# Longfield Solar Farm Draft position statement on Landscape and Visual Impact

Prepared for: Essex County Council,  
Chelmsford City Council, Braintree District  
Council

14<sup>th</sup> July 2022

10-12 A

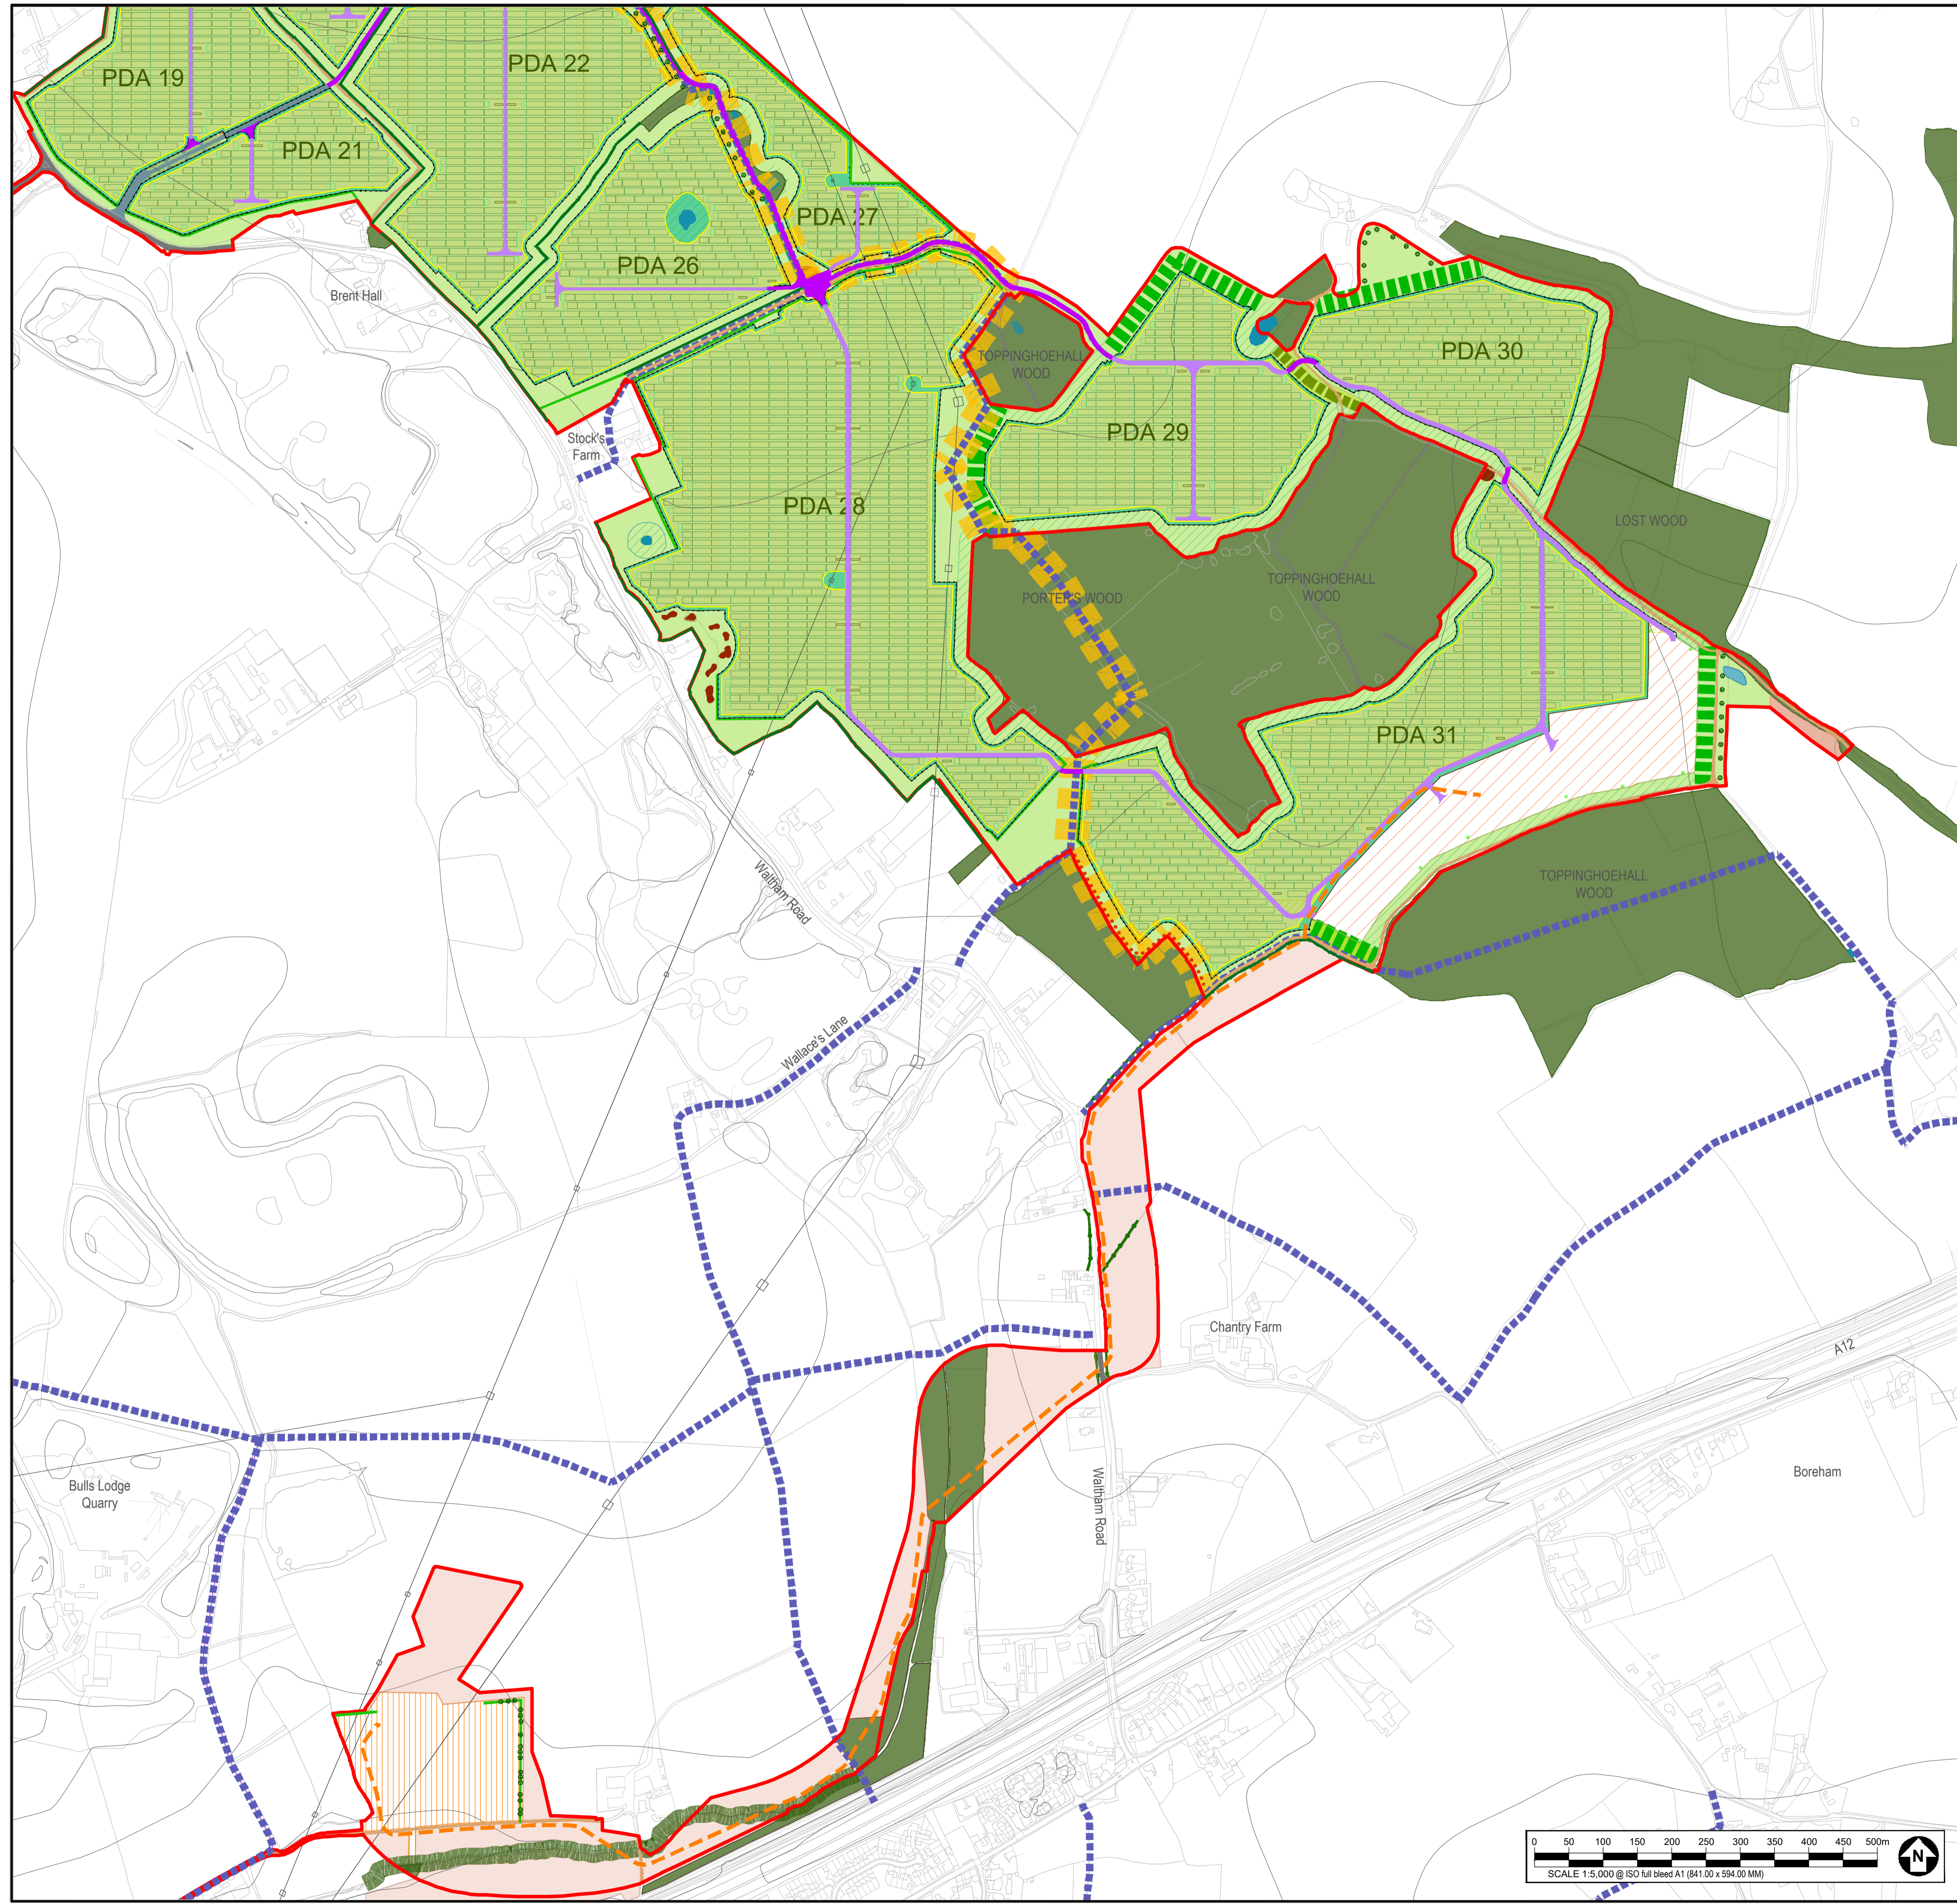
The Landscape masterplan and discussions had focussed on enhancement to hedges alongside the protected lanes and this is illustrated on the Landscape Masterplan. The Vegetation Removal Plan in the ES appears to show removal of vegetation along part of Noakes Farm Lane.

Along part of Noakes Farm Lane vegetation removal is to be proposed to each side of the carriageway. This part of the Lane is designated as a Protected Lane in BDC's emerging Local Plan under policy LPP 46 and, as such, the policy is clear that any proposals that would have a materially adverse impact on the physical appearance of these protected lanes will not be permitted.

Where the Lane turns to run east-west the current proposal is to remove a length of hedgerow for approximately 93m. The hedgerow is not continuous at this point so approximately 42m of hedge planting would be removed. We understand that the trees would be retained and a replacement hedgerow planted following construction, nevertheless, this would adversely impact the physical appearance of the protected lane.

The hedgerow has not yet been surveyed in detail, although we understand that a detailed survey of the hedge and trees is to be undertaken. There may be alternatives to hedgerow removal which

should be considered. The visibility splay lengths are generated by traffic speeds so a lower speed limit during construction could reduce the requirement. Traffic management of vehicles crossing the Lane could also avoid the need to remove the hedge. Management of the hedgerow by facing up or cutting back to improve visibility could also be explored.

As the plans stand at present the proposals are contrary to the protected lanes policy.
